ARUN DISTRICT COUNCIL

We are writing to make known our objection to the following planning application - BR/91/11/99 Hillsborough Road, Bognor.

Dissapproval of REF BR/91/11

Proposed roof extension and loft conversion
79 Hillsboro Road Bognor Regis

Proposed Southwest Elevation
Scale 1:100

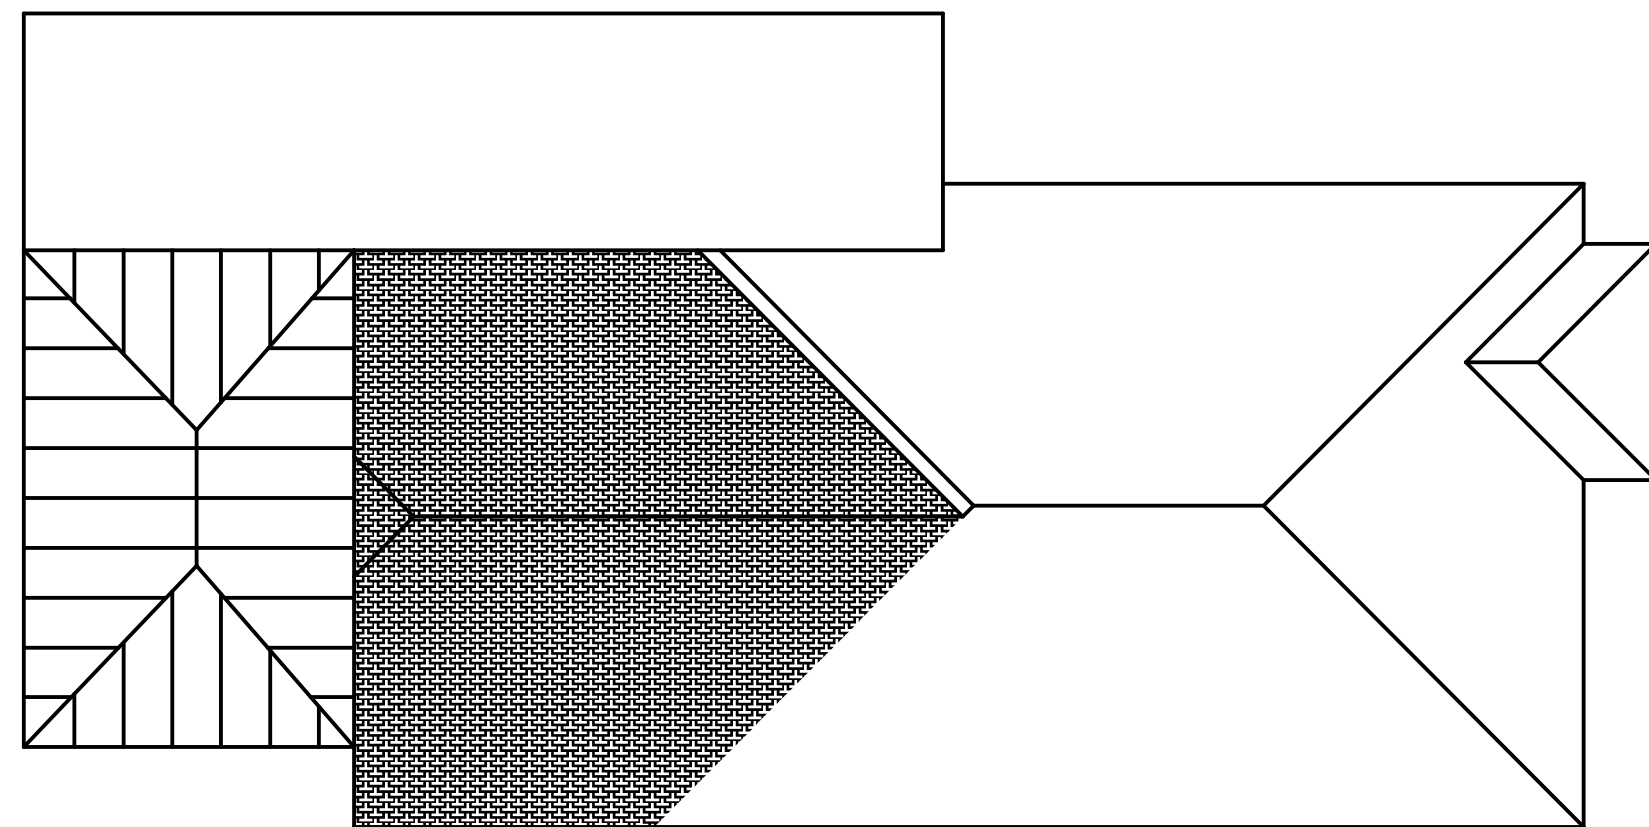
This extension is far too big for the situation it's in - in between three or four bungalows. We have a small back garden which will be totally overlooked, with the loss of privacy, sunlight etc. This extension ruins virtually the whole length of our rear garden.

I understand looking on the internet my neighbour who's property runs along the bottom of 3 Bungalows on the Chichester Rd. is planning a High railed roof extension with lots of windows overlooking all our properties 2 of which are totally secluded from anyone looking into our gardens. due to this my neighbour has a large deciduous in his garden and was the reason for buying this Bungalow.

*I DO NOT WANT THIS TO GO A HEAD IT WILL STOP MY LIGHT. AND FEEL OVER
POWERING. □
MR WAYNE HAS SENT THIS EMAIL FOR ME. MR LEE*

*IF THIS GOES AHEAD IT WILL BLOCK OUR LIGHT AND SUN .
AND TAKE ALL OUR PRIVACY AWAY.
SURELY THIS PROPERTY IS OVER DEVELOPED ALLREADY.
HOWEVER I DONT MIND DEVELOPMENT TO EXCITING LOFT WITH ONE VELUX
FROSTED MY SIDE .*

*NOT HAPPY WITH NEW BUILD AT REAR. FEEL THIS IS OVER POWERING TO
PROPERTY'S AROUND . WHICH ARE BUNGERLOWS NOT HOUSES.*
